CITY OF ALBUQUERQUE

December 26, 2019

RE: 833 Dolores Dr. NW
Grading and Drainage Plan
Engineer's Stamp Date: 12/24/19
Hydrology File: J11D040

Based upon the information provided in your resubmittal received 12/24/19, the Grading and Drainage Plan is approved for Building Permit.

ENGINEER'S SEAL	833 DOLORES DR. GRADING AND DRAINAGE PLAN	DRAWN BY DEM
DAVID SOULE REGISTERED PROFESSIONAL ENGINEER 12/13/19		DATE 12-12-19
DAVID SOULE P.E. #14522	 1608 CENTRAL AVENUE SE SUITE 201 ALBUQUERQUE, NM 87106 (505) 972-0899	833 DOLORES.DWG
		SHEET # C1
		JOB #

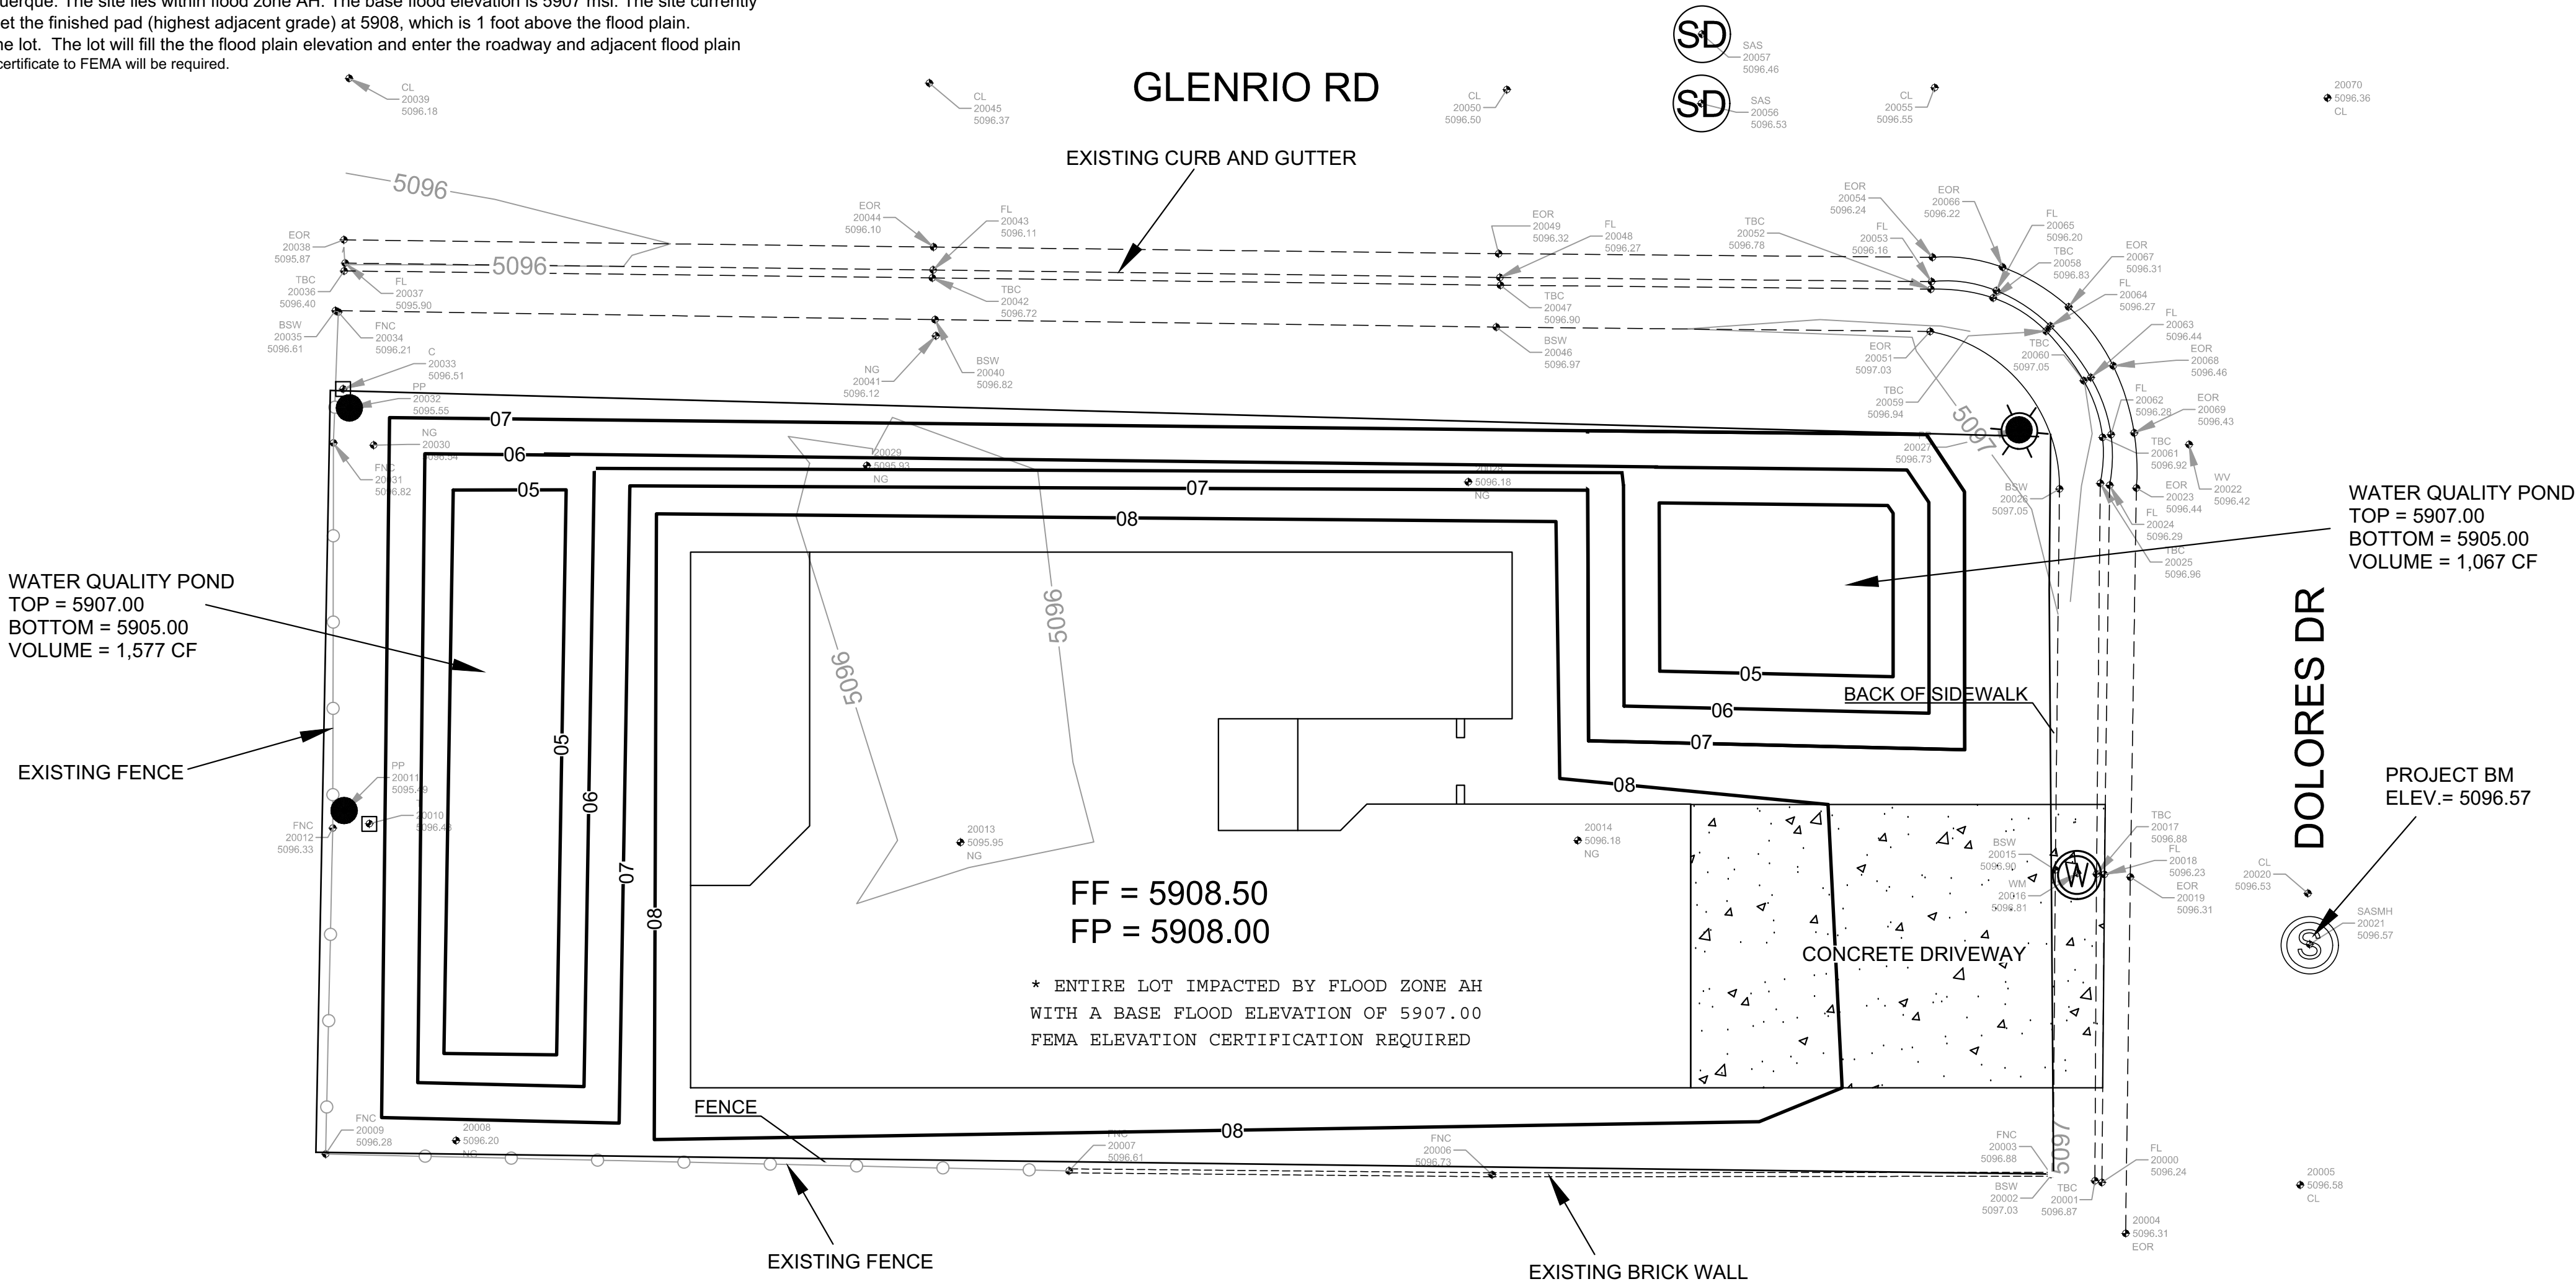
1. As stated on the plans, this site is located in a floodplain (AH – Elev 5907) and must have a floodplain development permit prior to issuing the Building Permit. The permit application must demonstrate zero rise to the base flood elevation, unless a Letter of Map Revision (LOMR) is being prepared. Please contact Rudy Rael, CFM for more information regarding floodplain development permits (rrael@cabq.gov or 924-3977).
2. Since this needs only needs a floodplain development permit, an administration fee of \$40 will be required at the time of resubmittal.
